Barbarick Transfer Station - COM-2346
EL PASO COUNTY PLANNING & COMMUNITY DEVELOPMENT
SIGN APPLICATION

Project: THE DUMP /GRAHAM INVESTMENTS
 Address:
 City/State: COLORADO SPRINGS, CO
 Sales Rep: CG
 Artist: CG
 Date: 2/7/24

SIGN PLAN COMMENT
RESPONSE

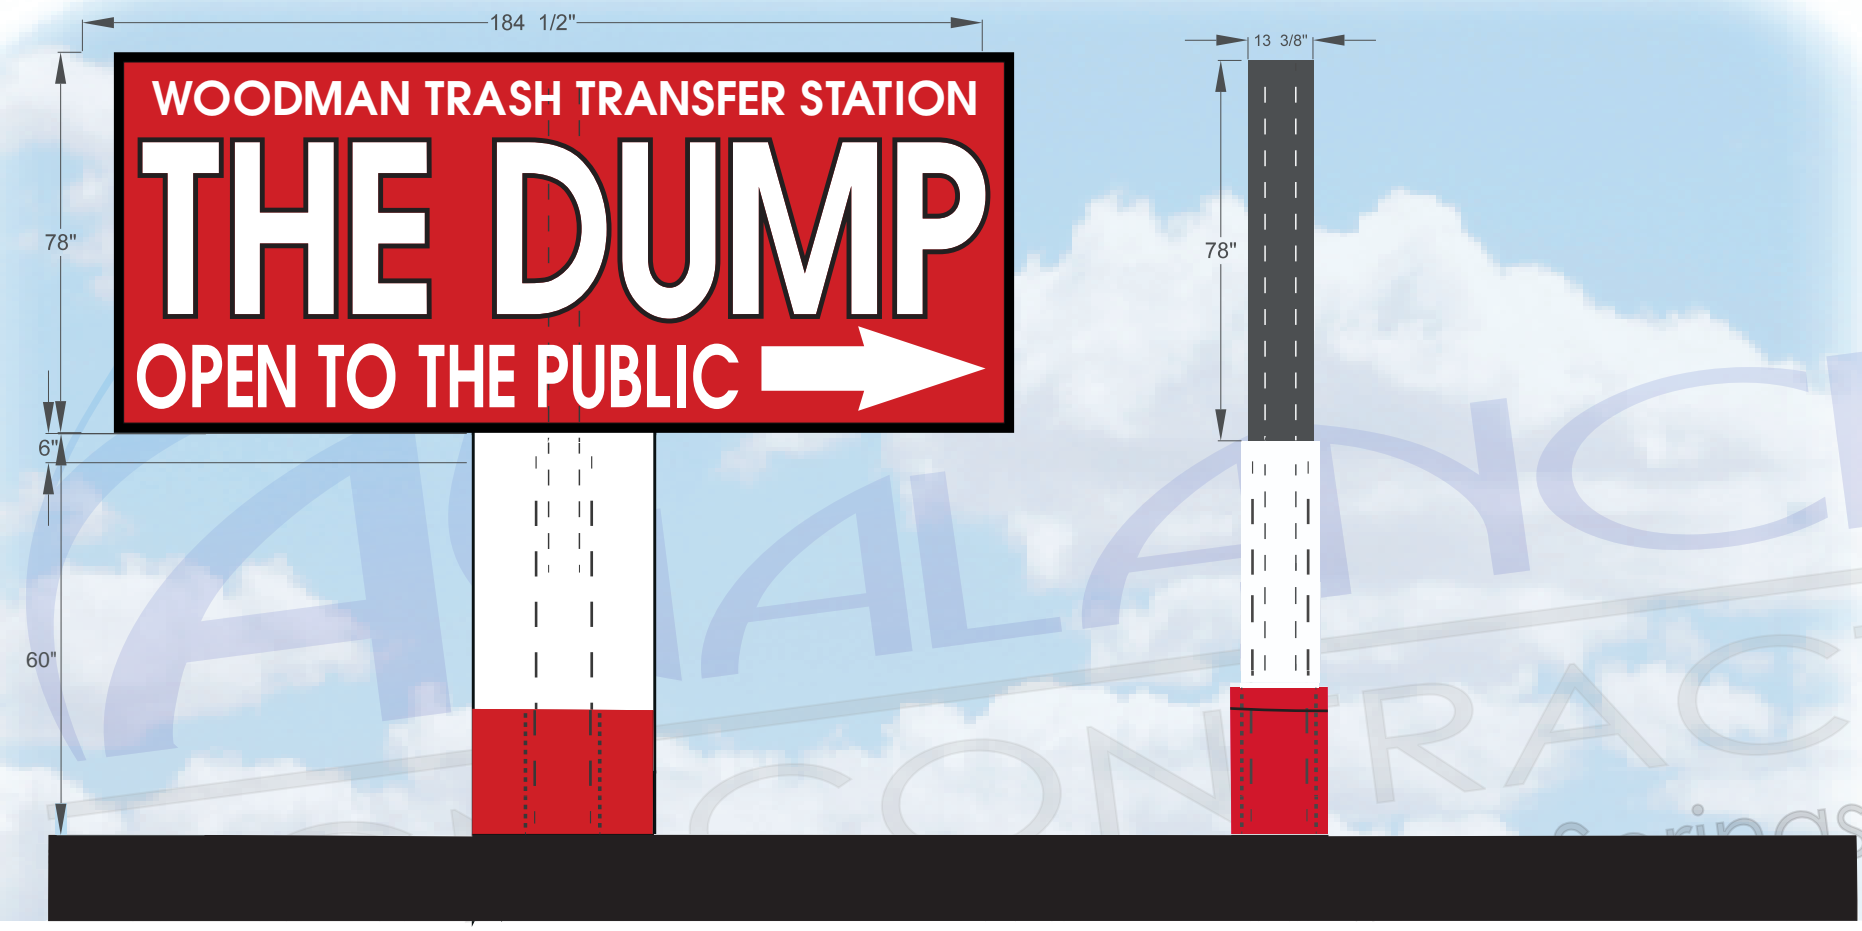
Please add:
 -table of allowed sq ft vs proposed
 - height of sign, in I-3 max height is 40 ft
